PAINT BRUSH HILLS FILING NO. 14

PROJECT NO. 10-014	FILE: \lang\Const Dwg\Storm - District\ST02.dwg	DATE: 06/25/20	SHEET 15 OF 25	ST02
DESIGNED BY: GT	SCALE: N/A	HORIZ: N/A	VERT: N/A	
DRAWN BY: CMN				
CHECKED BY: WAS

STORM PLAN & PROFILE

STORM 3 STA 1+00.00 TO STA 8+50.00

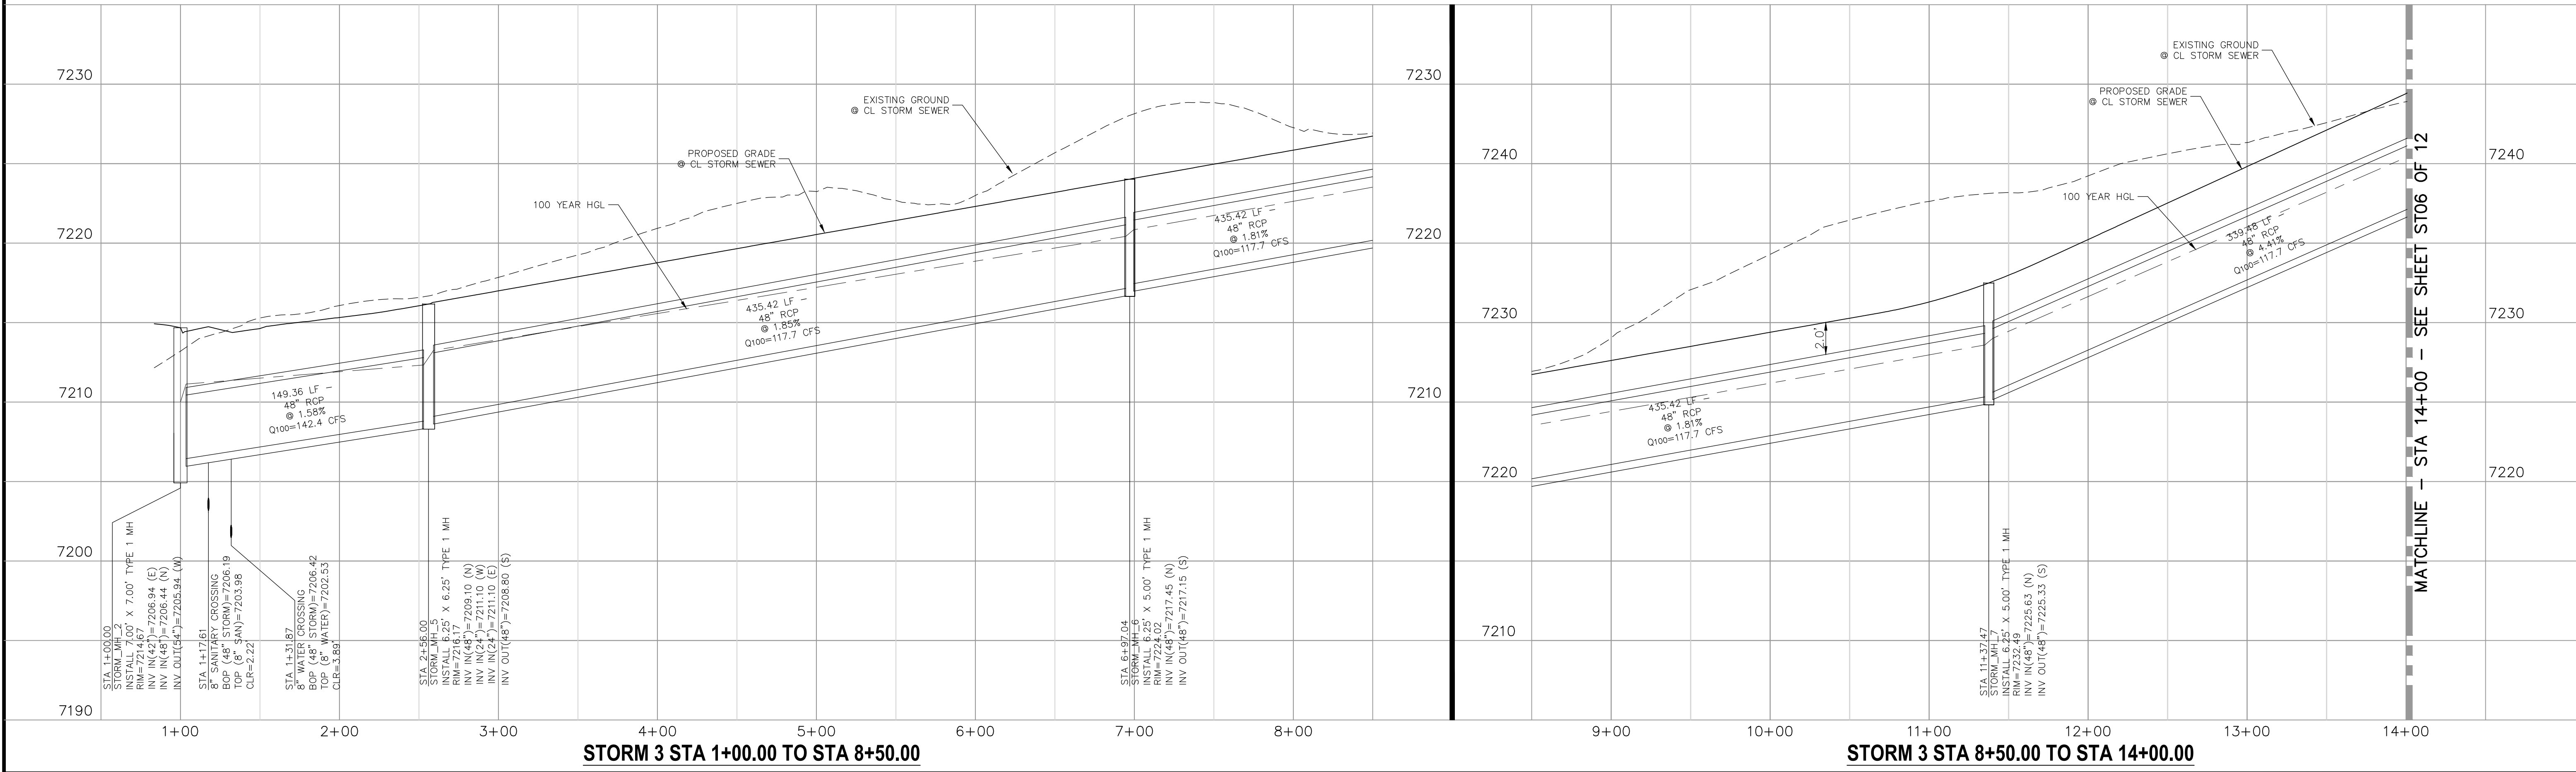
Show the HGL on all storm sewer profiles

COMMENT ADDRESSED, HGL SHOWN.

STORM 3 STA 14+00.00 TO STA 27+57.42

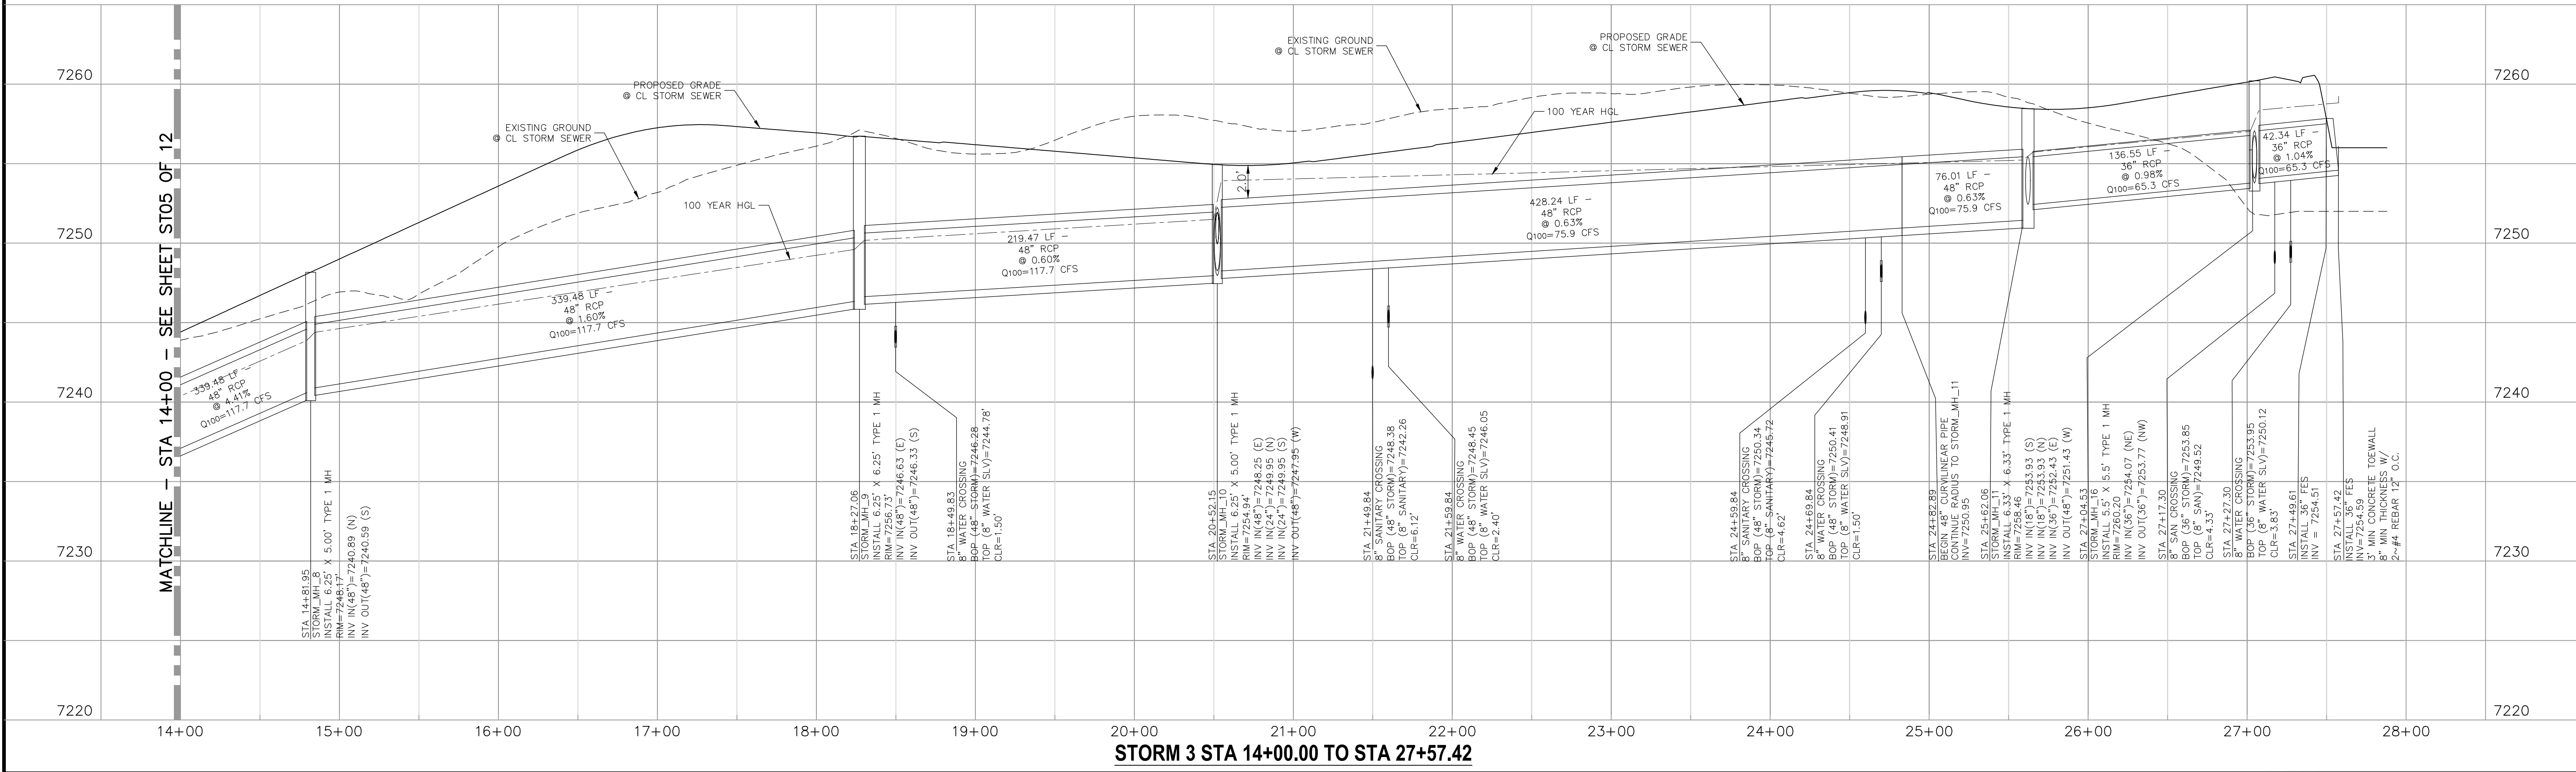
Submit the pipe manufacturer's specification for the pipes showing the design meets the radius of curvature for the given pipe diameter.

Per ECM 3.3.1.D where it is necessary to design for a pressure head watertight joints with a 100-year service life is required. Update plans to identify the sections pipe requiring the watertight joints with 100-yr service life.

Add a dimension label stating minimum 2' cover required from finished grade to top of pipe

COMMENT ADDRESSED. NOTE ADDED TO PLANS. EMAIL FROM RINKER TO BE FORWARDED TO EPC. RINKER MINIMUM PIPE RADIUS TABLE ON SHEET ST03.

COMMENT ADDRESSED. NOTE ADDED TO PLANS. EMAIL FROM RINKER TO BE FORWARDED TO EPC.

COMMENT ADDRESSED. DIMENSION SHOWN IN PROFILE.
